**WEST SUSSEX COUNTY COUNCIL
STRATEGIC PLANNING CONSULTATION**

SUBJECT: BR/150/12 - Various landscape works. Demolition of wall to be re-built to 1.5m in height. Remove parking from frontage & create new car park to west side. New pavement to front of building, footpath & paved circle.

**University Of Chichester, Dome House, Upper Bognor Road, Bognor Regis,
West Sussex, PO21 1HR**

Drawing: Proposed Car Park Layout

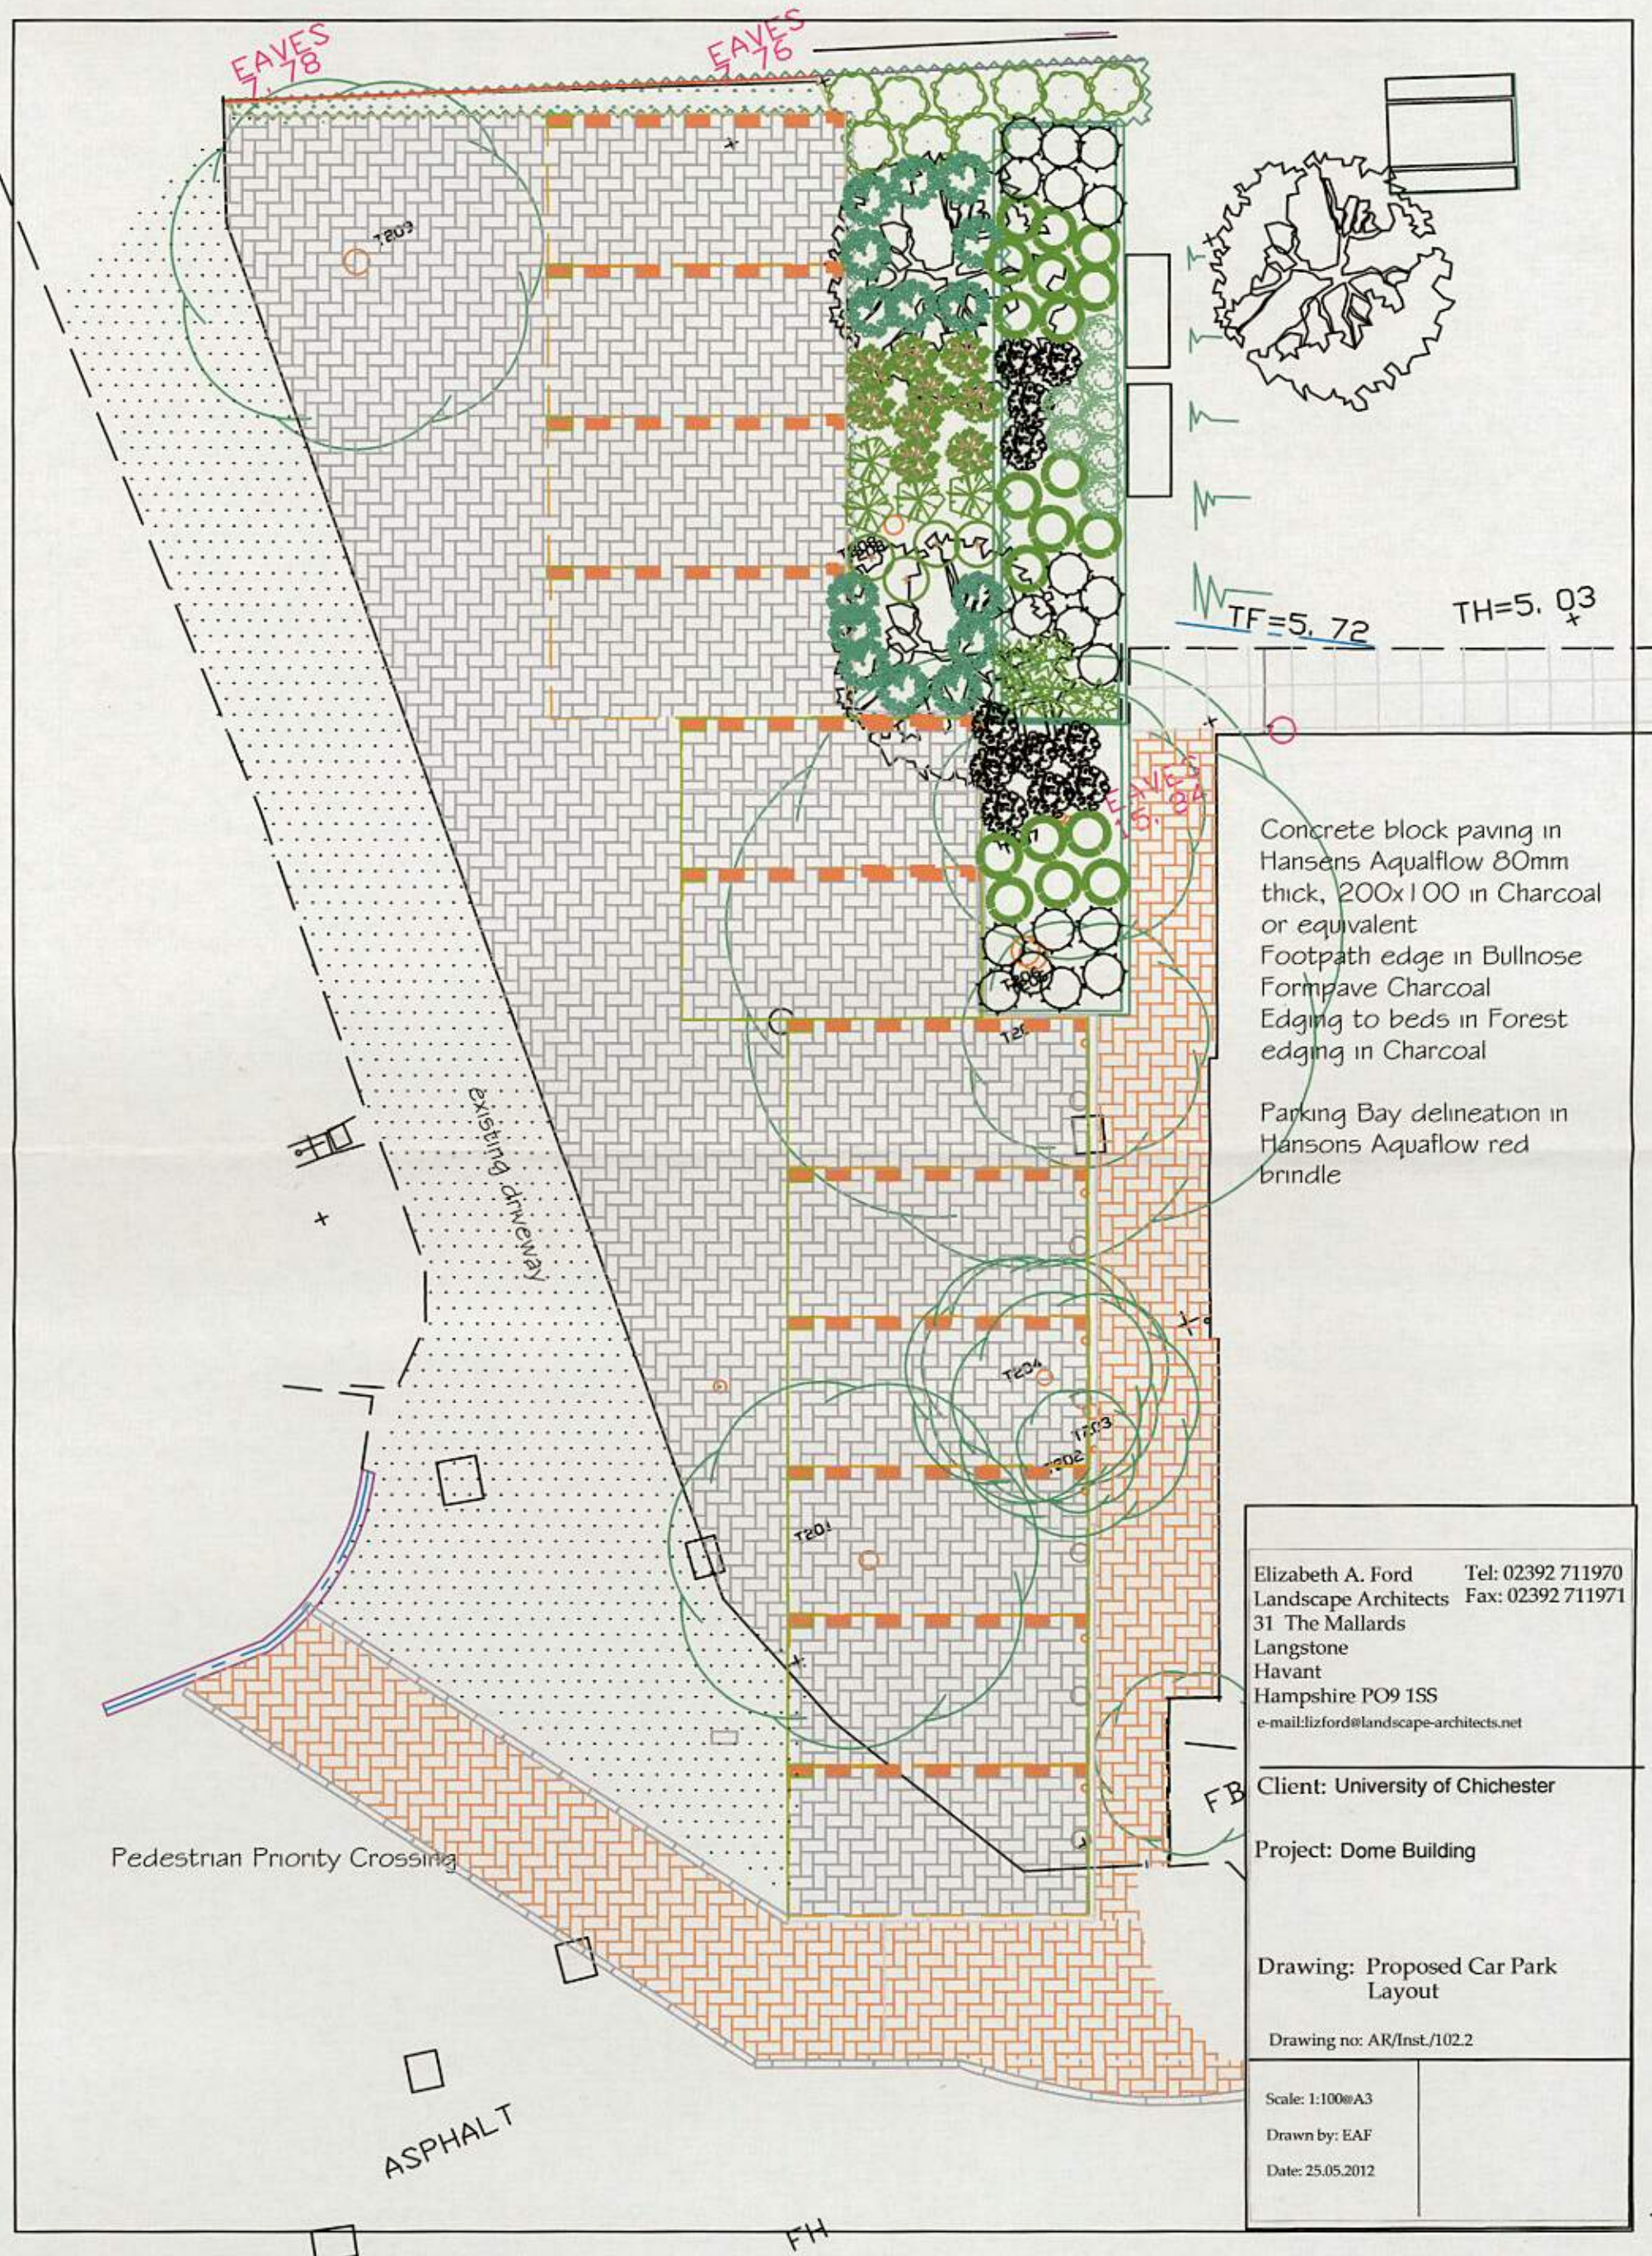
It is proposed for the 12 parking spaces available to the front (south) of the Dome building to be relocated to the west of the building.

No Highway objection subject to the following condition.
